Was 03/2011/0140, now 03/2011/0559

**Planning Applications, Ribble Valley District  
D3-11-0140 land adjacent to High Gill Barn, Tosside**

DWG -05E

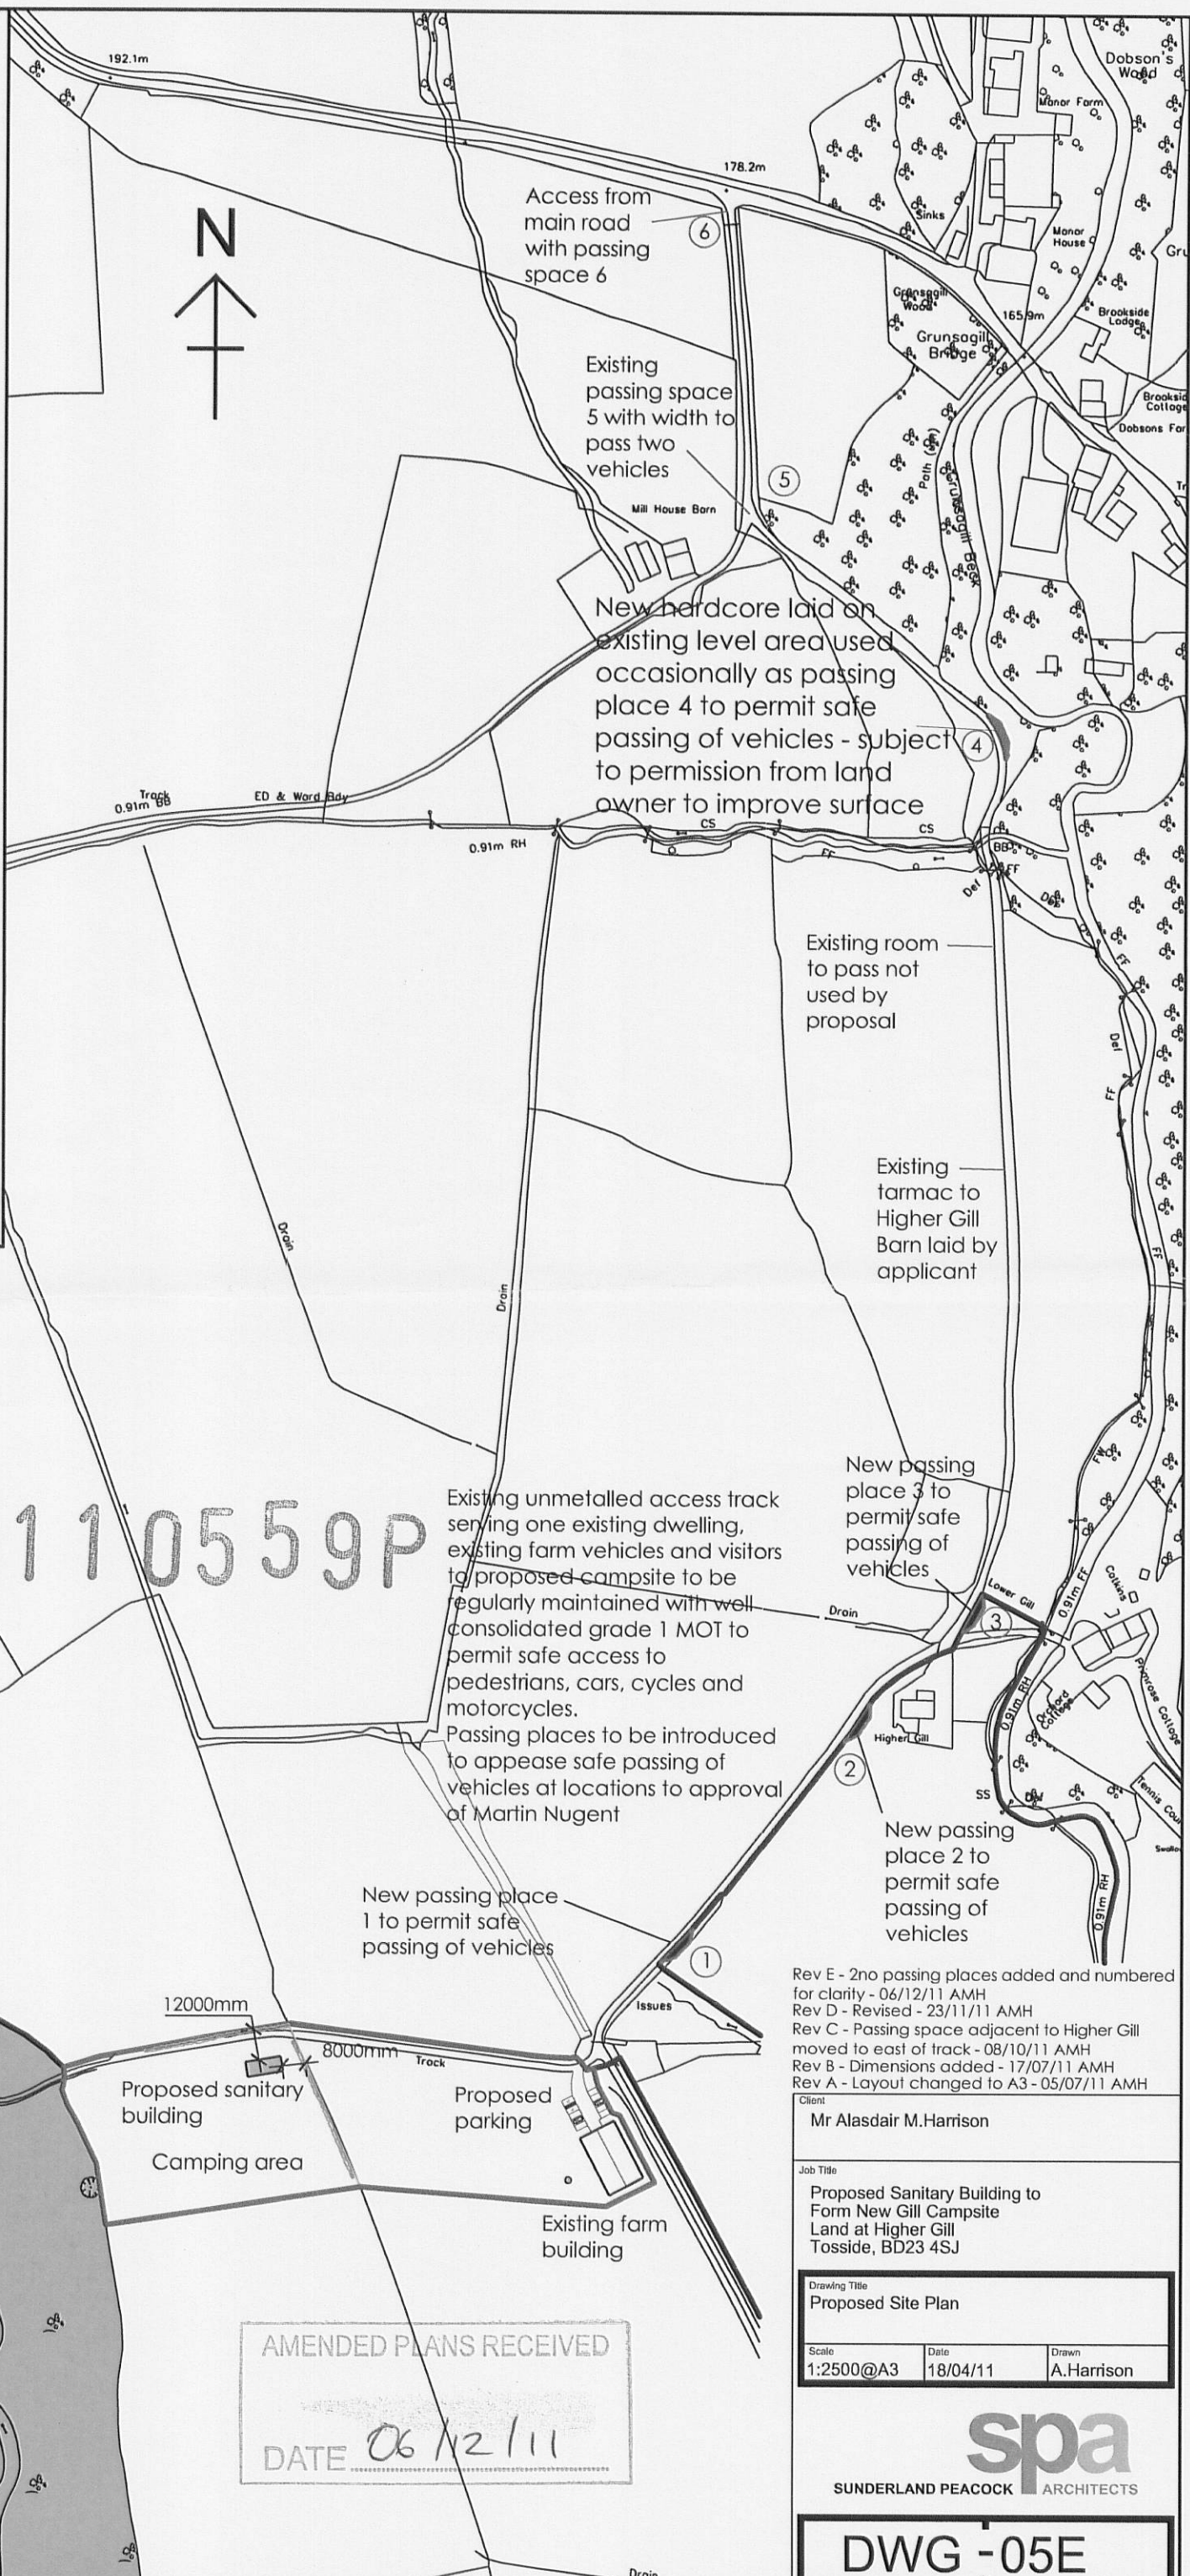
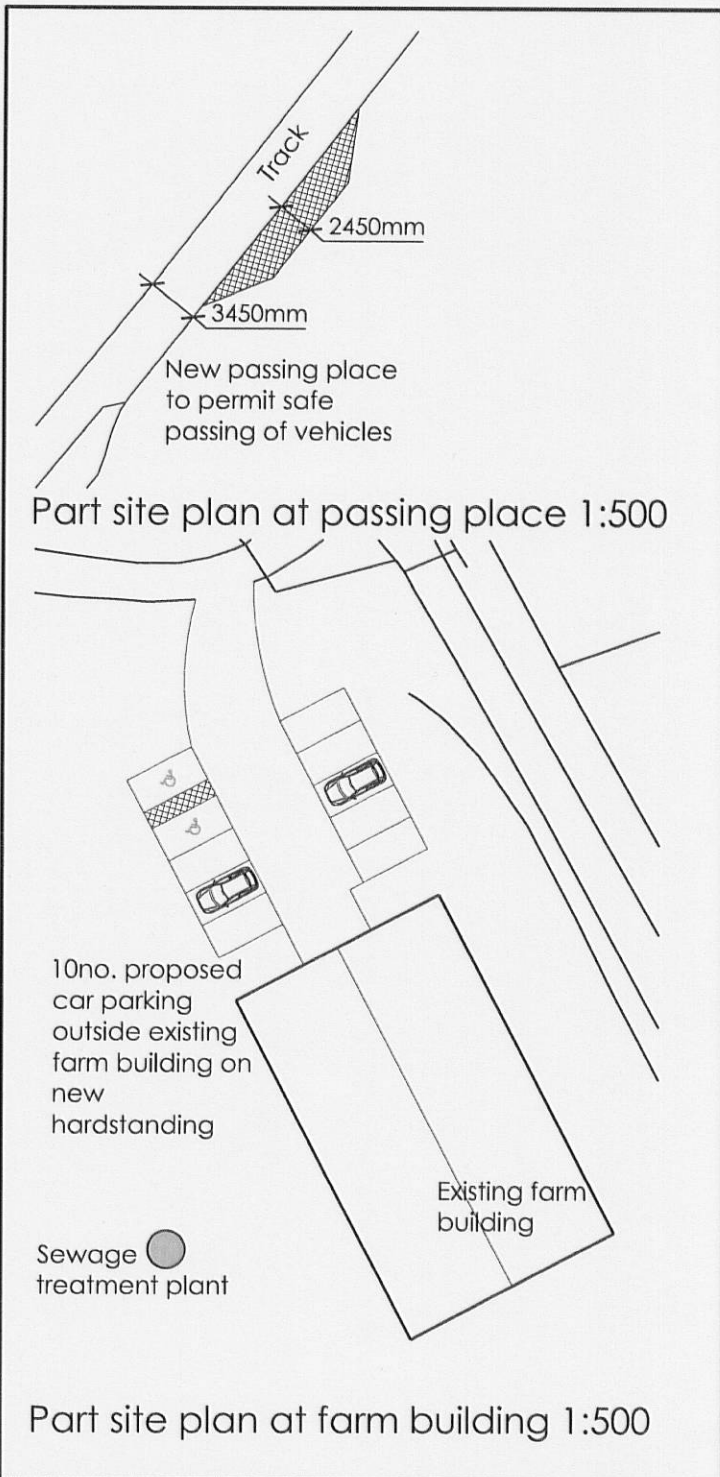
The proposed improvements to the access road, identified on Dwg-05 and dated 18 April 2011, secures significant highway safety benefits and brings this track up to a standard consistent with a route suitable for the general public. The passing places that have been identified will provide a safe means of access for the public travelling to the site.

Subject to the introduction of the highway measures as identified on the amended plans, I have no objection to this application on highway safety grounds.
